From: Stephen Gee [<mailto:Stephen.Gee@westsussex.gov.uk>]
Sent: 07 November 2017 12:01
To: Juan Baeza
Cc: Planning.Responses
Subject: WA/73/17 Land East of Wandleys Lane and West of West Walberton Lane, Fontwell.

**WEST SUSSEX COUNTY COUNCIL
PLANNING SERVICES CONSULTATION**

SUBJECT: WA/73/17/OUT - Outline Planning Application with some matters reserved for up to 157 No. residential dwellings including 30% affordable. This application is a Departure from the Development Plan.

Land East of Wandleys Lane, and West of West Walberton Lane, Fontwell

Appendix N A29 / A27 Mitigation

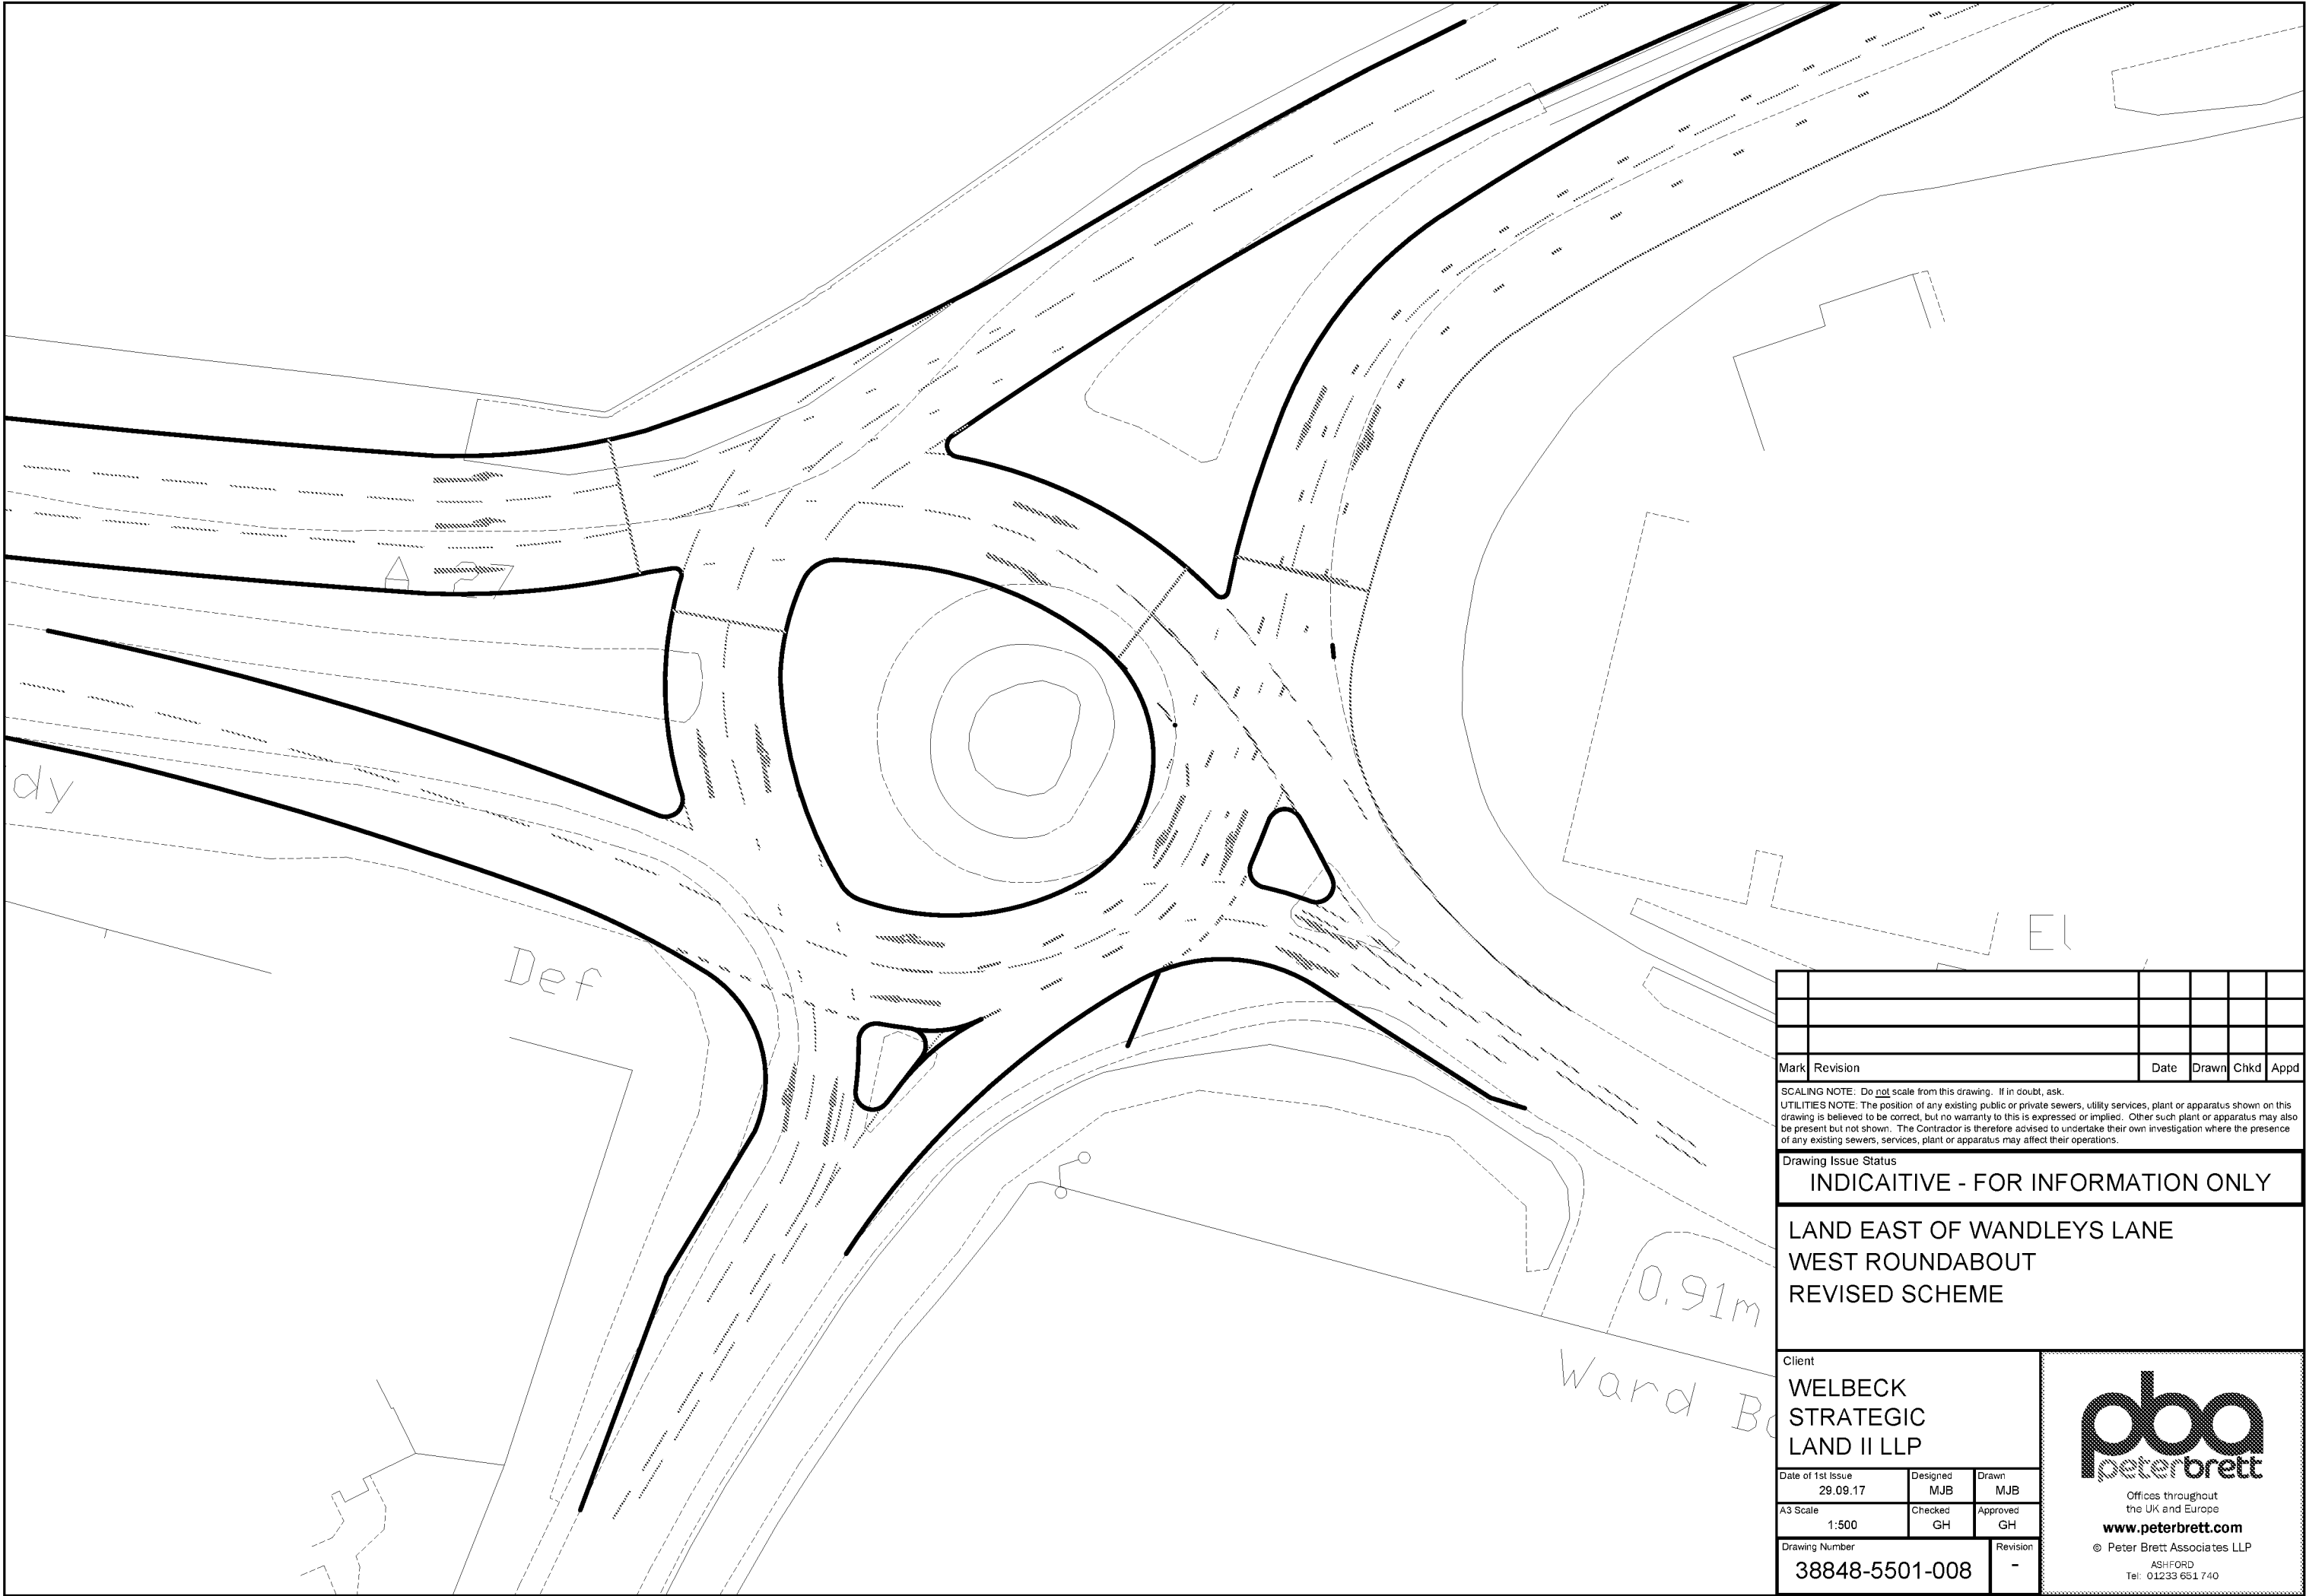
The junction is responsibility of Highways England and as such we will provide further comment with regard to the modelling and mitigation proposed once these have been agreed. From an initial review concerns are raised about:

- Internal link lengths are all set at 60PCUs
- A PM peak hour of 17:30 to 18:30 is stated which does not correlate to that stated in the TA (5.2.5) of 16:30-17:30.
- Different inputs utilised to application WA/44/17/OUT at Tye Lane which were agreed with Highways England this as resulted in significantly different outputs and impact of the mitigation scheme proposed that appears to just replicate that of the Tye Lane application.

Once the modelling parameters have been agreed, comments can be provided on the suitability of the mitigation measures proposed and their impacts on the local highway network.

Improvements to the A27/A29 junction should be discussed following the provision of revised modelling. It is noted that applicant is agreeable to a monitory contribution made towards amending the strategic improvements already being promoted at this junction to be delivered by the permitted development of WA/22/15/OUT.
